**STATE SIGNIFICANT DEVELOPMENT:
Section 96(1A) Modification Application**

**SICEEP, DARLING SQUARE, SOUTH EAST PLOT,
SYDNEY**

SSD 6633 MOD 1

Environmental Assessment Report
Section 96(1A) of the *Environmental Planning
and Assessment Act 1979*

TITLE
Plans
L00 Podium Ground
 WHEN PRINTED AT 50% @ A3 DRAWING SCALES IS 1:400

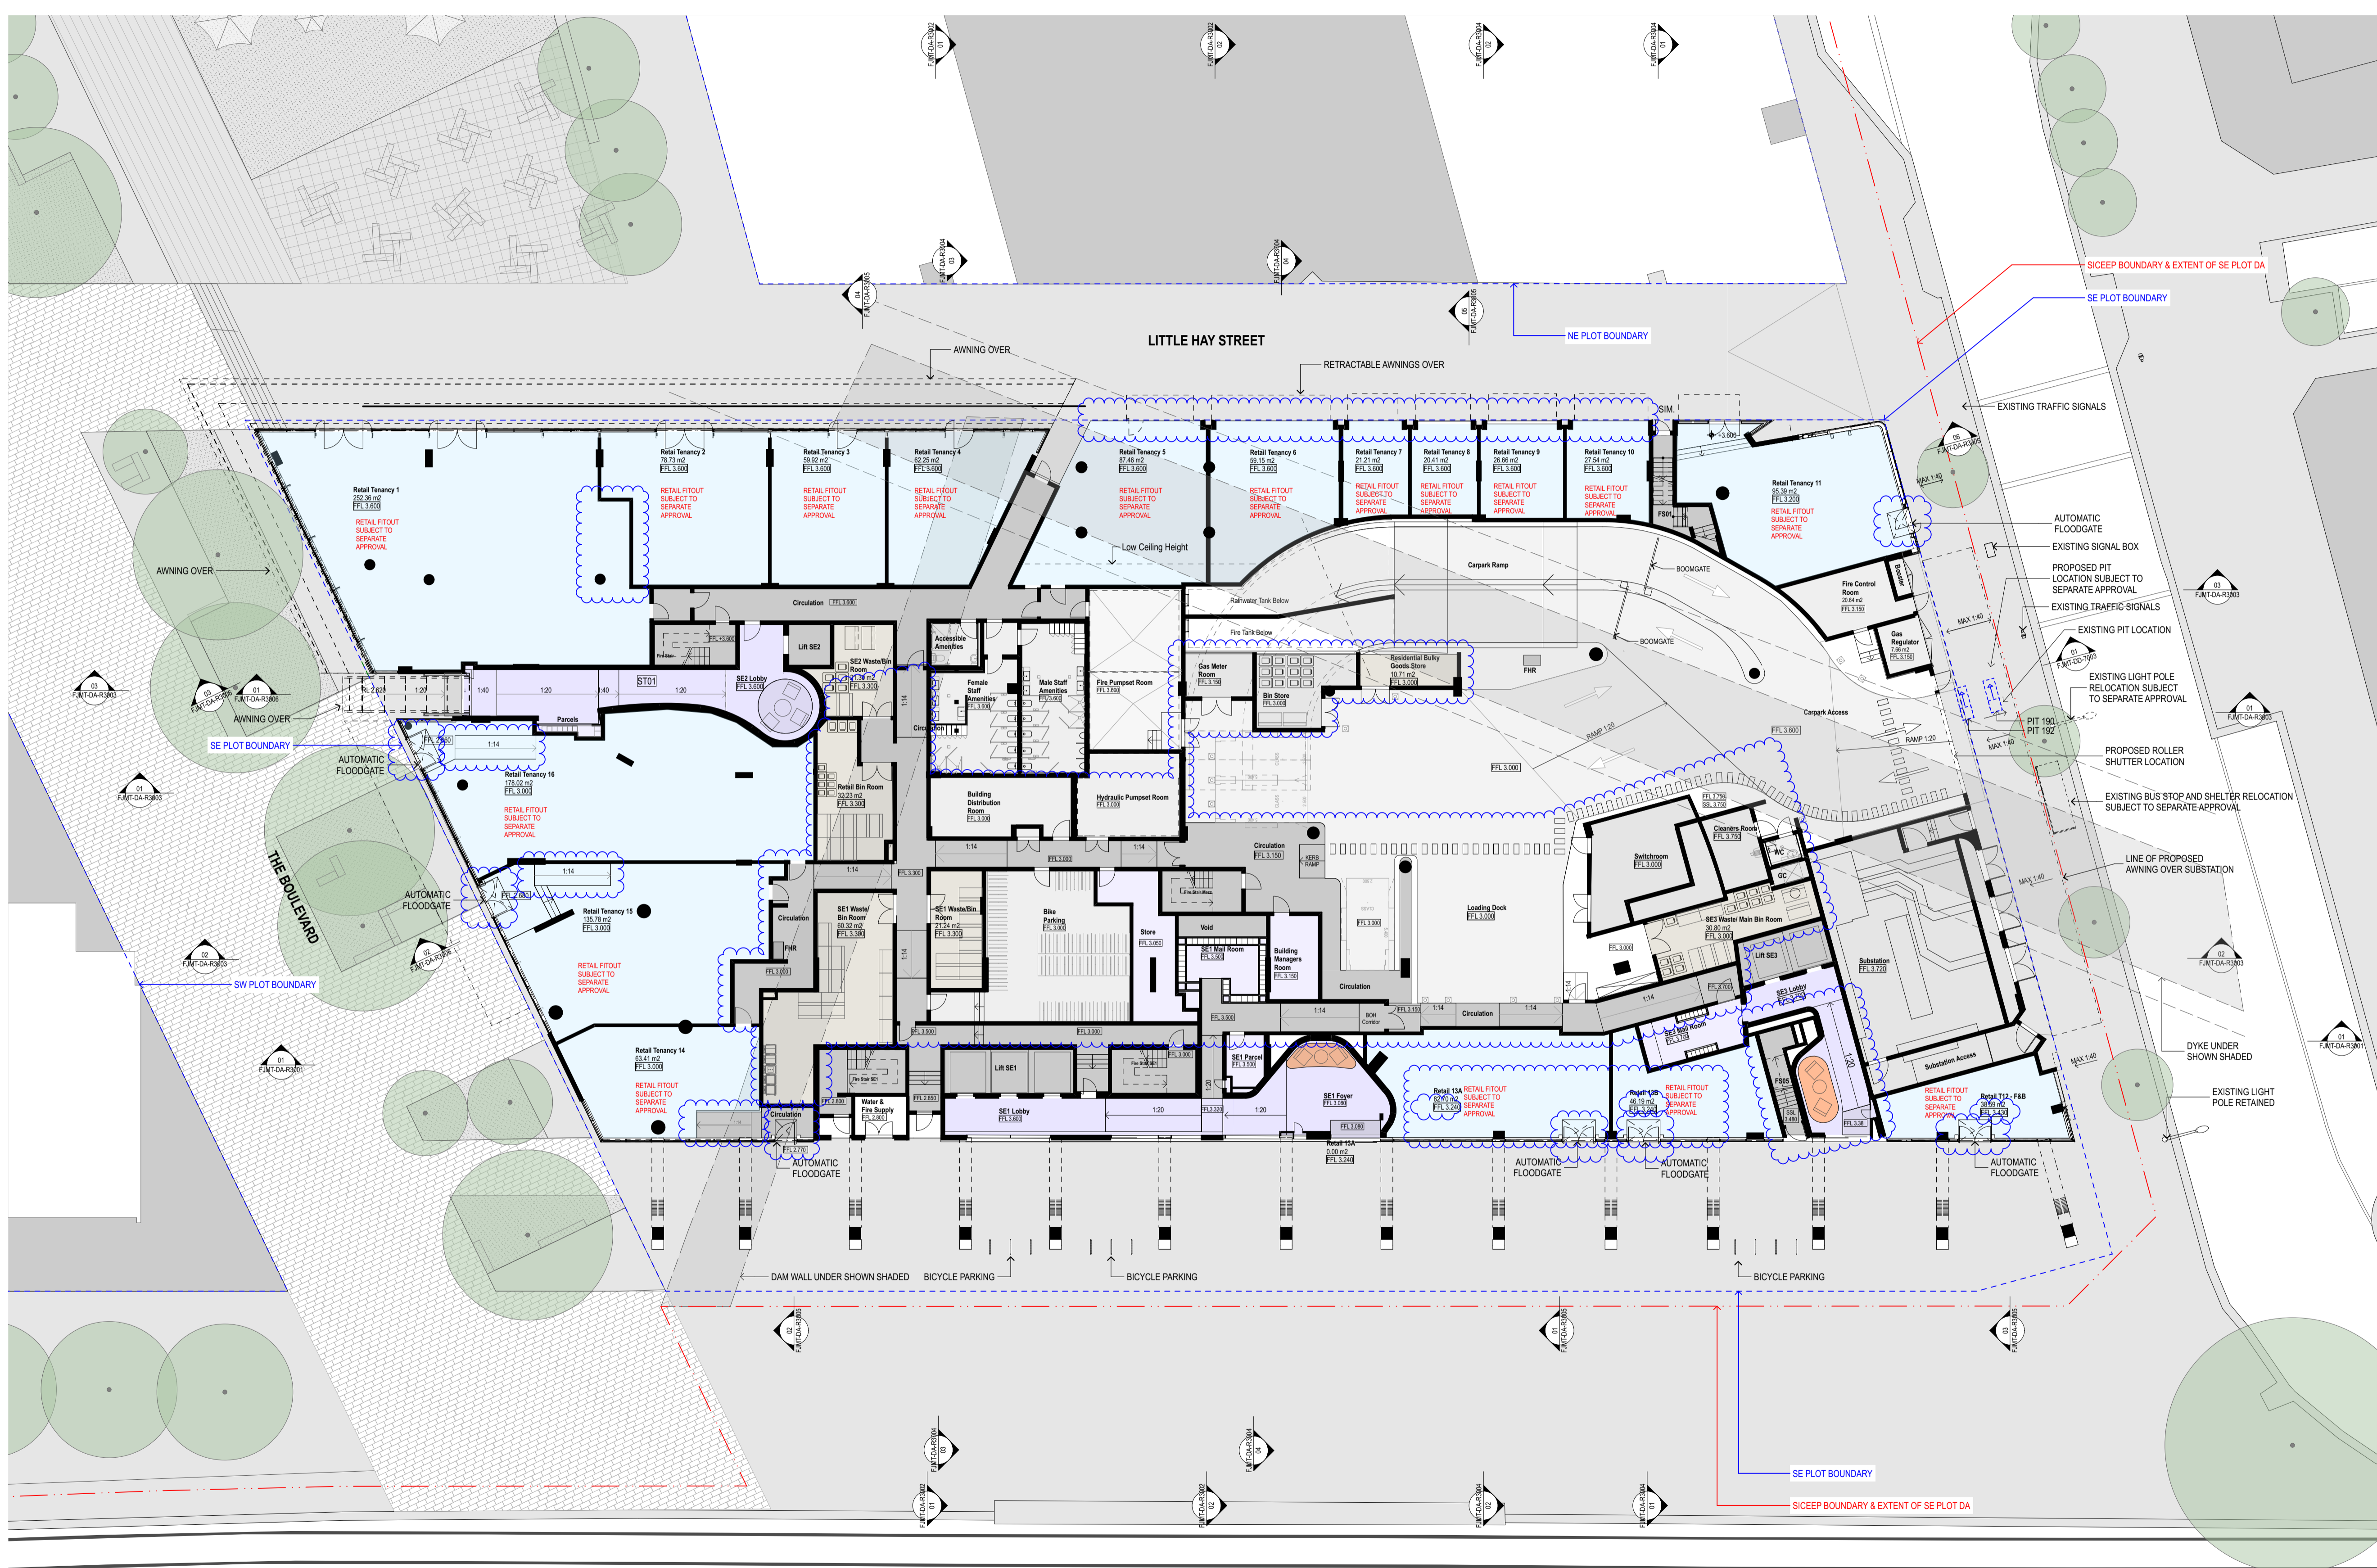
The proposal seeks to divide one retail unit (12A) into two smaller retail tenancies and provide one additional opening fronting Hay Street (13A and 13B) (**Figures 3 and 4**). The Department considers this will improve the activation of the Hay Street colonnade, which was a principal consideration in the assessment of the Stage 1 Concept Plan and SSD approval. In particular, it will minimise the

extent of blank wall, increase the retail mix of the development and create a more diverse, stimulating and attractive street. This design change will also increase shopfront design flexibility to suit a more diverse range of future retail tenants.

The proposal seeks to remove the mezzanine above the ground floor of retail unit 1 (North Western corner of the building at the intersection of Little Hay Street and The Boulevard), and update the design of the shopfront (**Figures 5 and 6**). The Department notes that the removal of the mezzanine is likely to add variety to the retail mix of the development as retail spaces with higher ceilings increase the flexibility of use and appeal to a broader range of tenants than spaces with more conventional, lower ceiling heights.

The Department considers that the proposed detailed design of the retail façade introduces pattern and texture which will improve the appearance of this corner of the building. Further, this design change to the shopfront and increase in floor to ceiling height is typical of other ground level retail spaces in this building and brings consistency to their appearance.
